Hornsea Project Four

Outline Design Plan TRACKED

Deadline: 4, Date: 10 May 2022

Document Reference: F2.13

Figure 6: Colour Sampling Exercise Results.

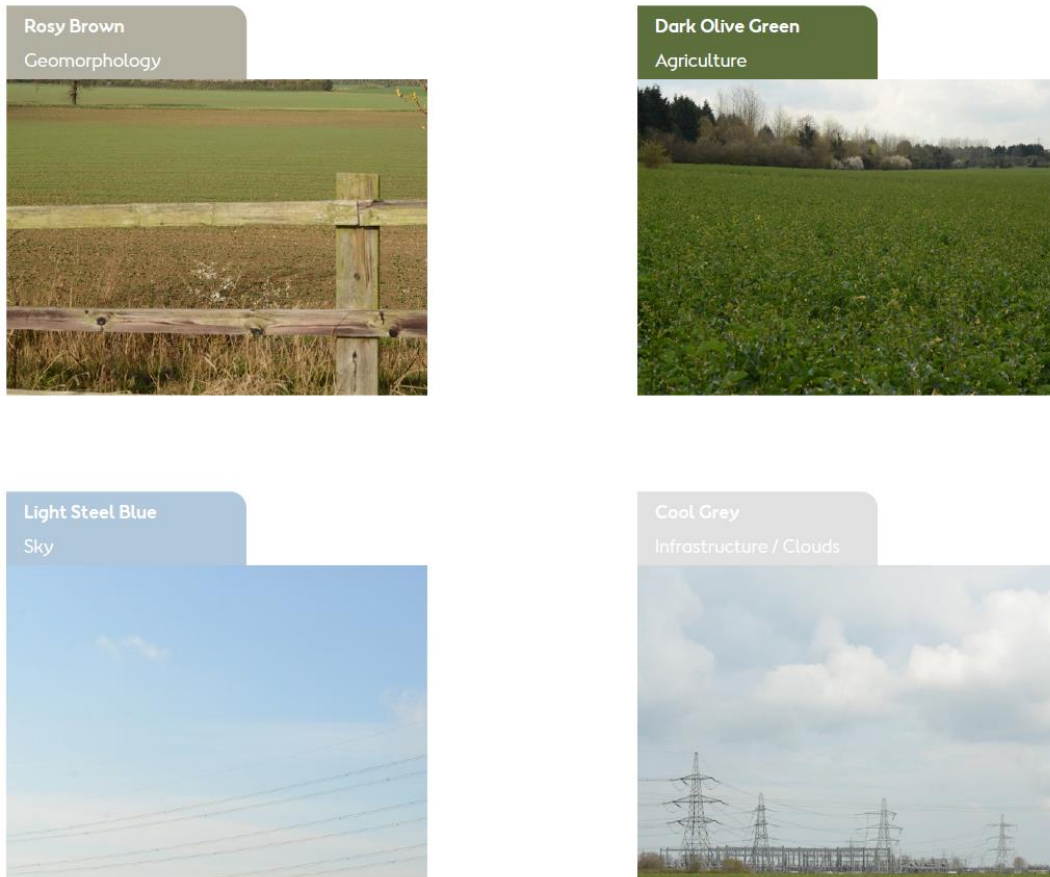
Rev	Page	Section	Description
01	N/A	N/A	Submitted as part of DCO Application
02	21	Figure 6	Amendment to Figure 6 specifying indicative colours in response to ISH2.
02	15	Table 3	Additional clarity regarding OnSS MDS to ensure consistency, further to clarification provided at Deadline 4.
03	13	6.2	Removal of word 'approximately' as set out in G1.6: OnSS and EBI Ground Levels Clarification Memo (AS-024).
